Stage 1 Road Safety Audit

**Residential Development, Shanganagh Castle,
Cork Little, Co. Dublin**

On behalf of **Dun Laoghaire Rathdown County Council**

December 2019

STREET 1 - LONGSECTION (1) SCALE: H 1:500,V 1:100. DATUM: 24.000

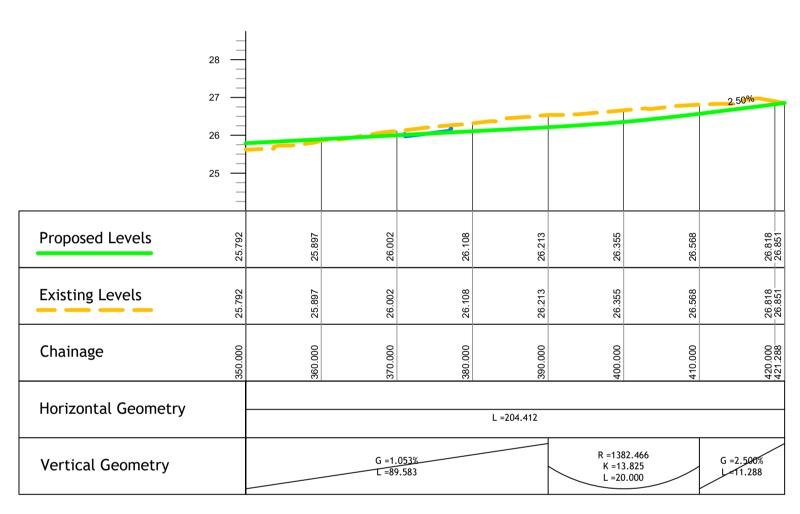
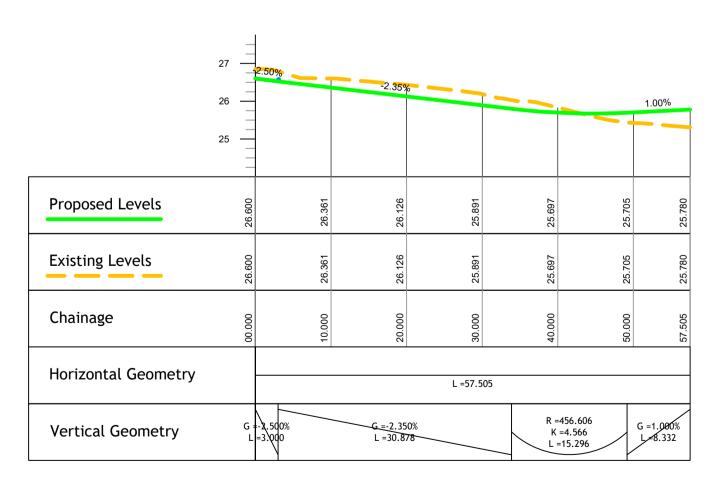
2.3.8 Junction of Street 1 with Street 6

Problem: The predominate traffic movement at this junction is likely to be from Street 6 into Street 1 and vice versa, however traffic from the cul-de-sac end of Street 1 is offered priority at the junction.

Hazard: It is likely users of Street 6 will become complacent over time and fail to yield at the junction. Impact with cul-de-sac traffic may result.

Recommendation: Amend the junction priority and implement a change in materials or road level to ensure the cul-de-sac traffic obey the change in priority.

2.3.7	Y	Y		
2.3.8	Y	Y		
2.3.9	Y	Y

STREET 5 - LONGSECTION (1) SCALE: H 1:500,V 1:100. DATUM: 26.000

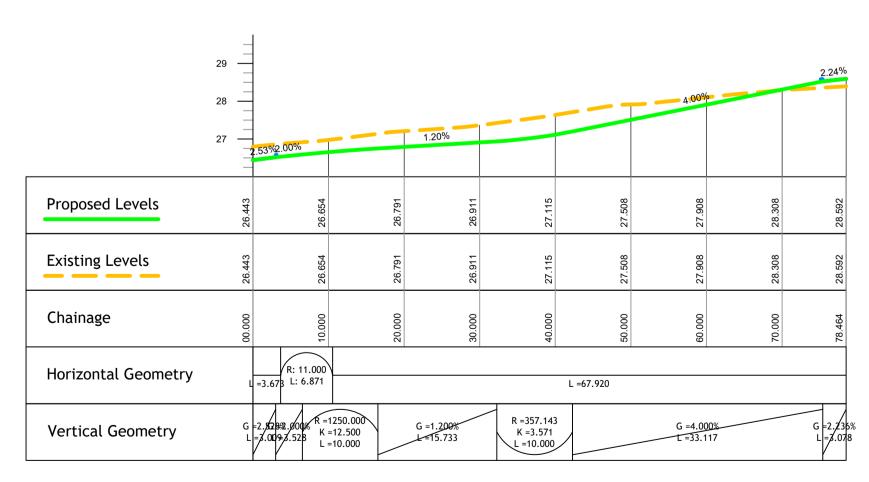
2.3.7 Junction Street 5 with Street 2

Problem: Street 5 seems to continue into Street 2 at the junction. Although Street 2 is a continuous alignment traffic traveling along this street must yield priority to Street 5 traffic.

Hazard: Impact between users of the two streets may occur.

Recommendation: Change the priority at the junction so Street 5 users yield to Street 2.
